**KIRKLEES METROPOLITAN COUNCIL
INVESTMENT & REGENERATION SERVICE**

**DELEGATED DECISION TO DETERMINE APPLICATIONS FOR
CONSENT, AGREEMENT OR APPROVAL REQUIRED BY CONDITION**

Reference No:	2024/44/90591/W
Site Address:	Land at, Lancaster Lane, Brockholes, Holmfirth, HD9 7BP
Description:	Discharge conditions 3 (internal estate roads) and 5 (future management and maintenance) on previous permission 2021/91578 (APP/Z4718/W/21/3284361) for erection of 9 detached dwellings with associated works
Recommending Officer:	John Holmes

DECISION – APPROVE DISCHARGE OF CONDITIONS

Client JAMES WOOD PETRIAN CONSTRUCTION	Drawing No TWP20-NTF-E02-005
Contract LAND OFF LANCASTER LANE BROCKHOLES HUDDERSFIELD	Revision A
Drawing PROPOSED RESIDENTIAL DEVELOPMENT LANCASTER LANE ACCESS DETAILS	Date Jan '24
	Scale 1:250-1:50-1:25 @ A1
	Drawn CAB
	Checked

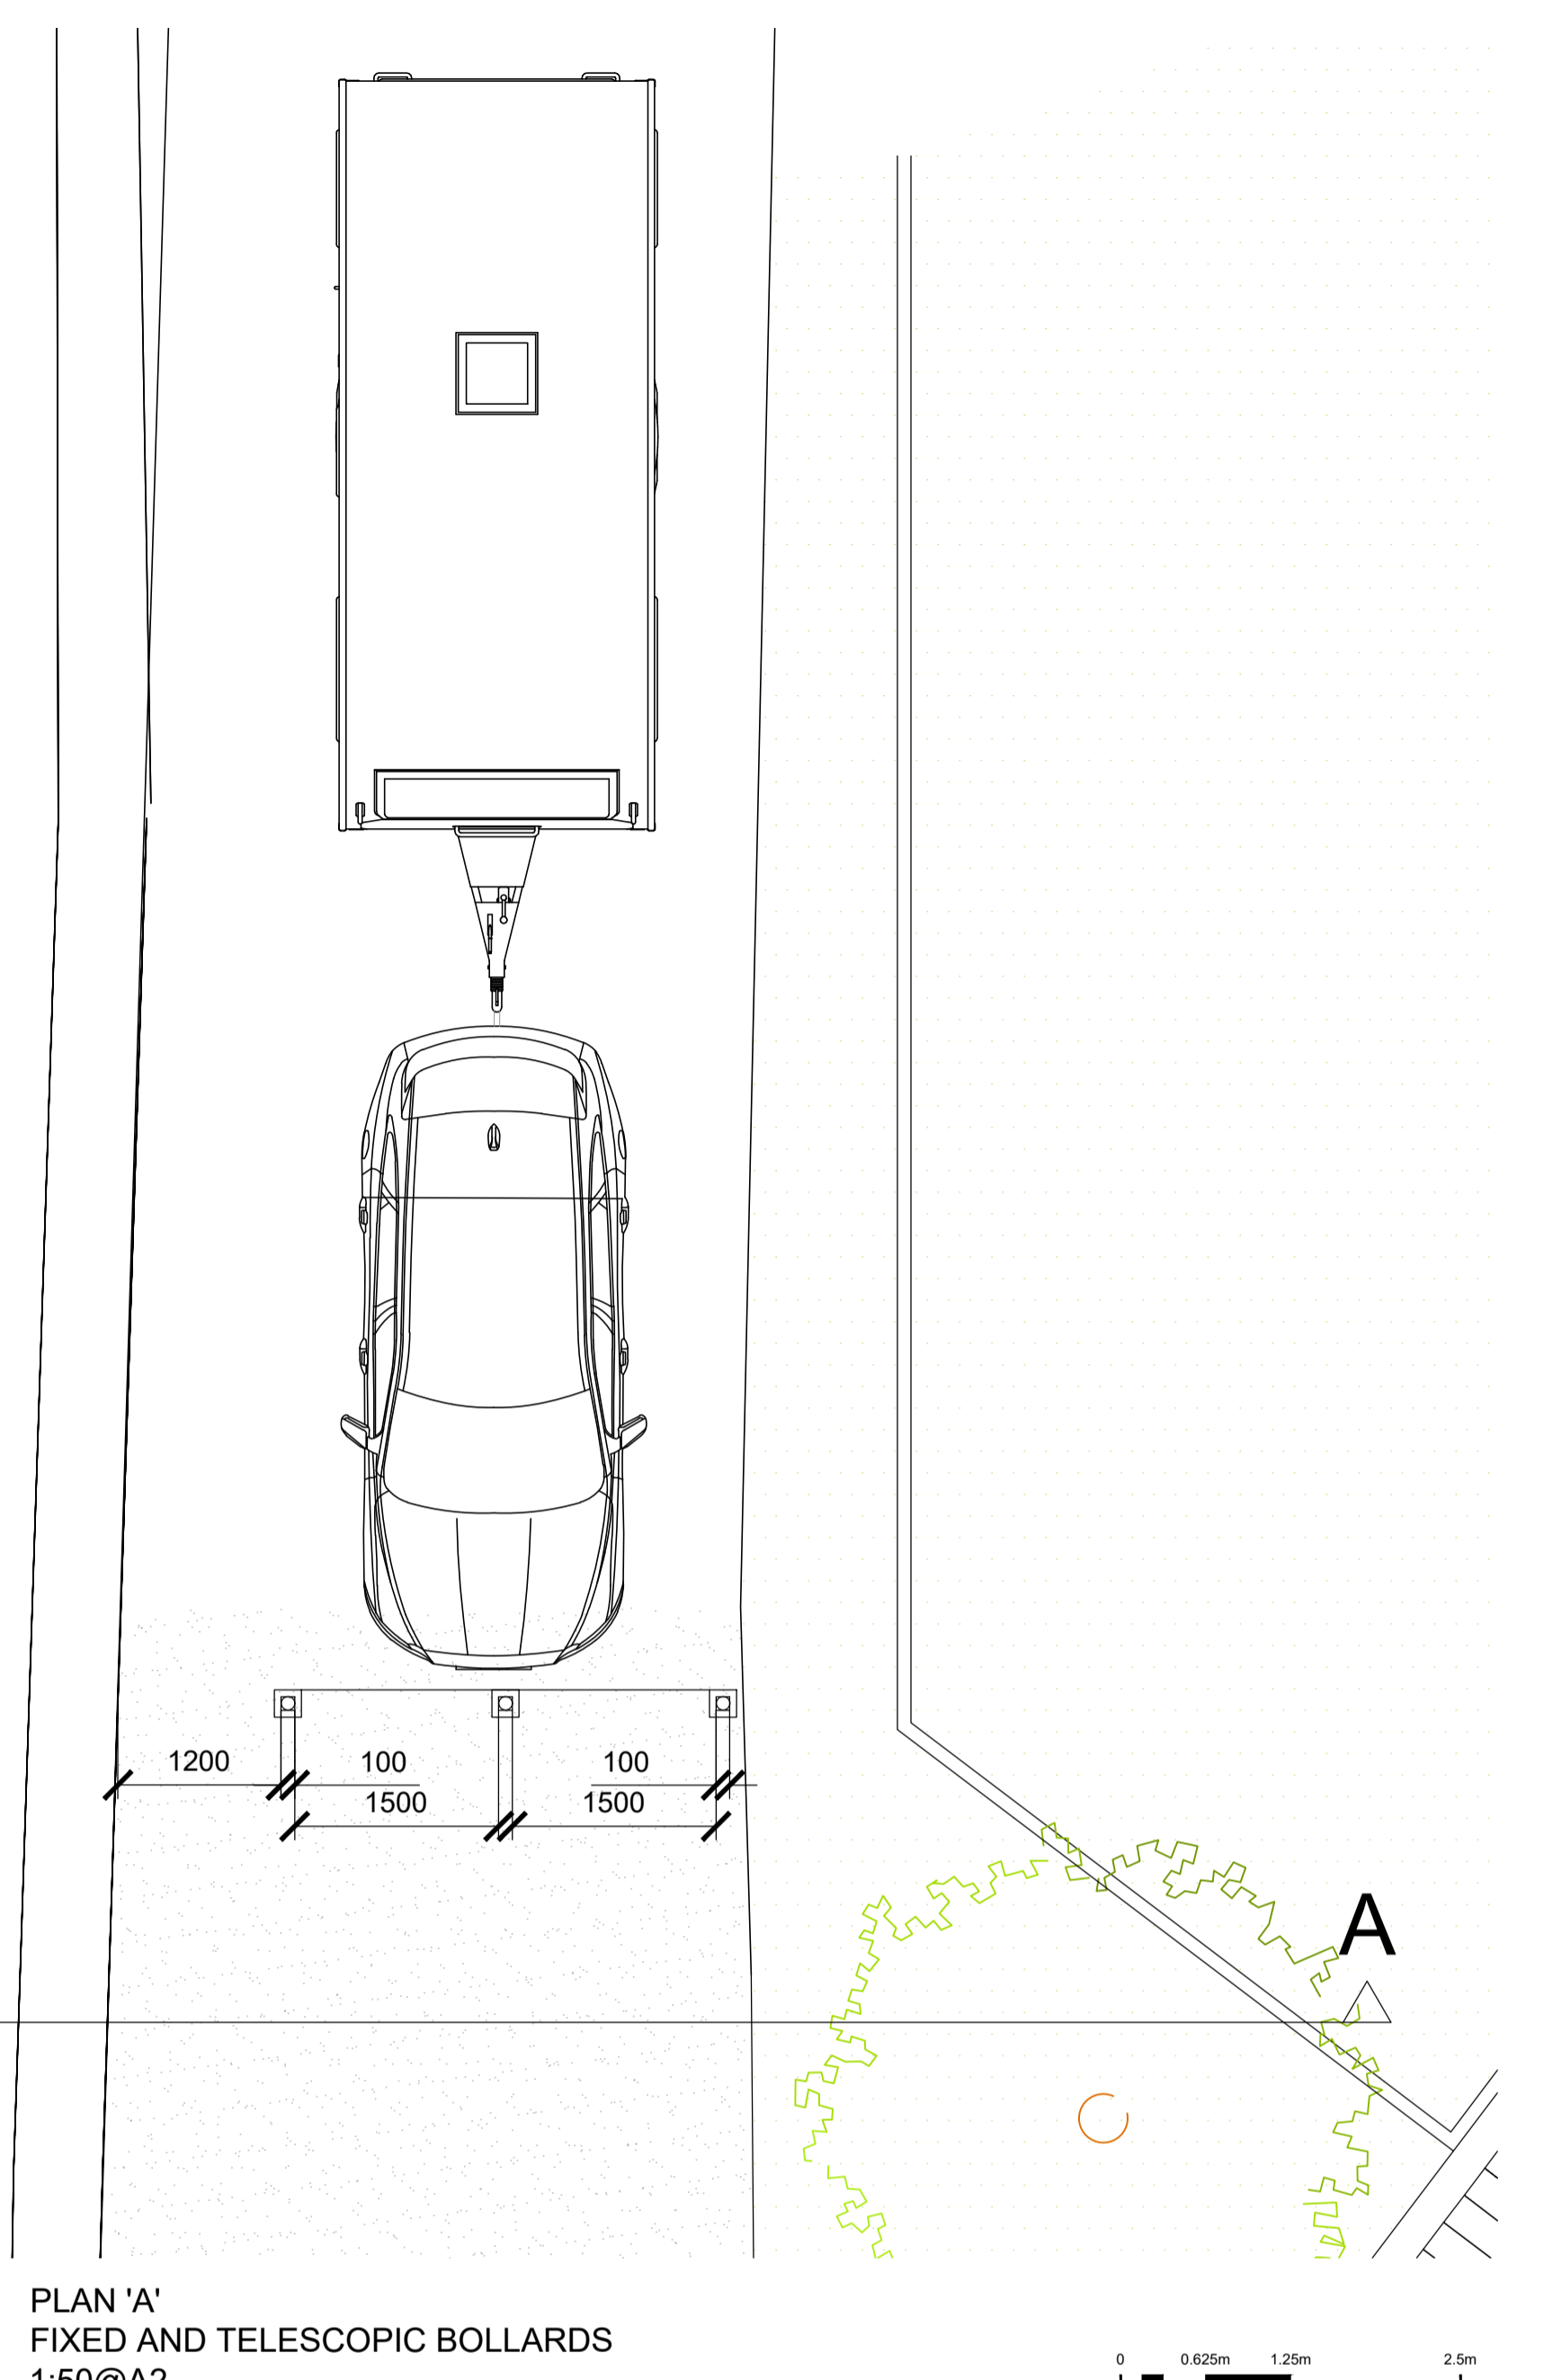
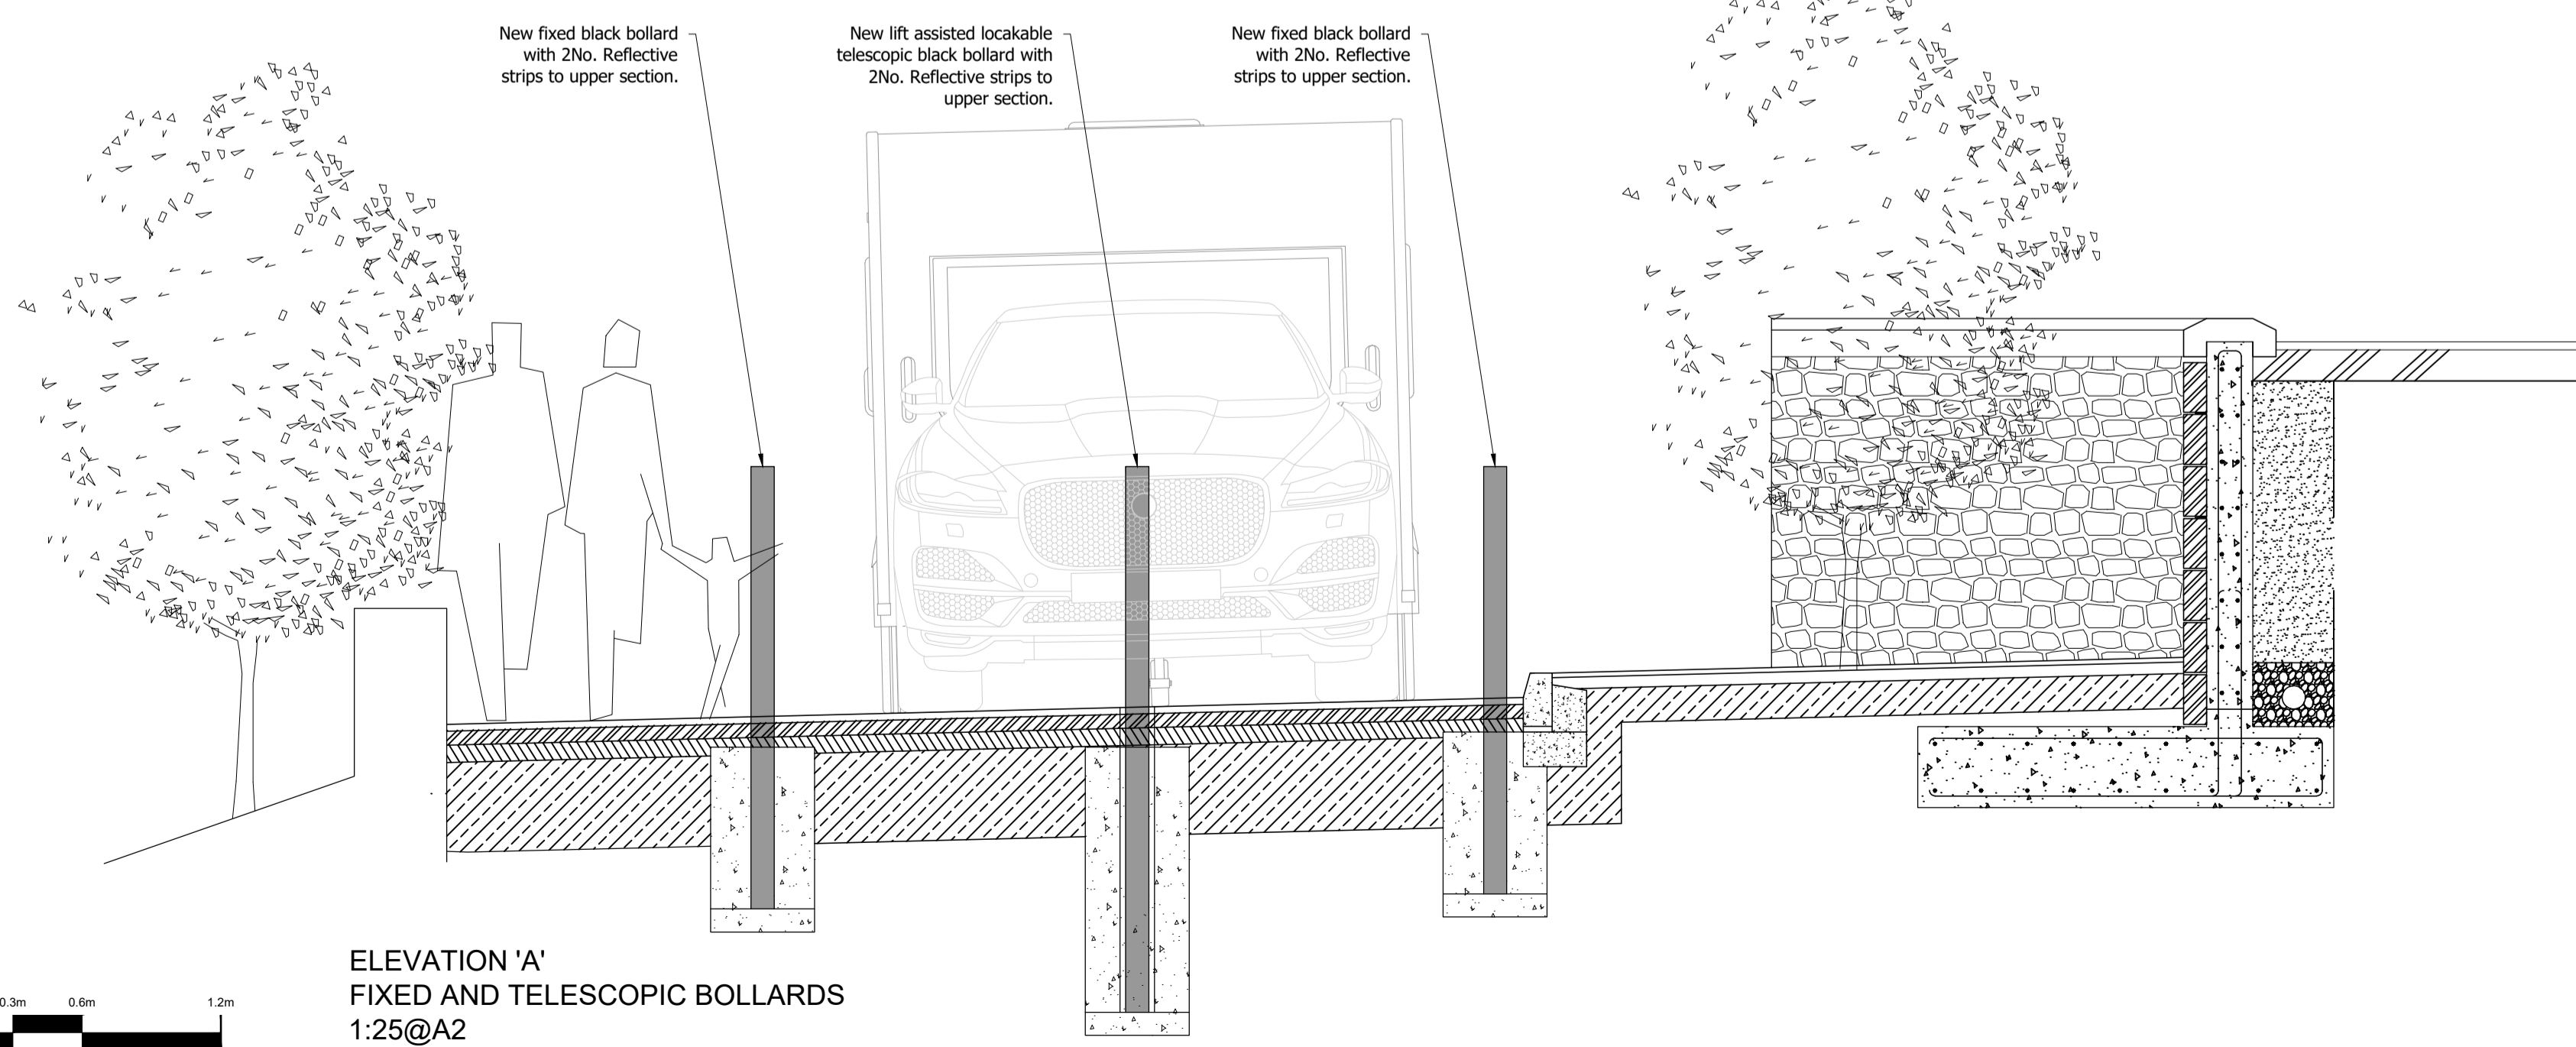
The Council's Highways Development Management Team and Highways Structures Team have been consulted regarding the submitted scheme. Verbal discussions have taken place with the Lead Local Flood Authority (LLFA) also. Following review and discussions, the entry control system to prevent vehicular access (provision of bollards) was amended. In addition, the surfacing being proposed was also amended.

Amendments have been made to the submitted scheme to address / accommodate comments which includes the surfacing and access control arrangements for the access.
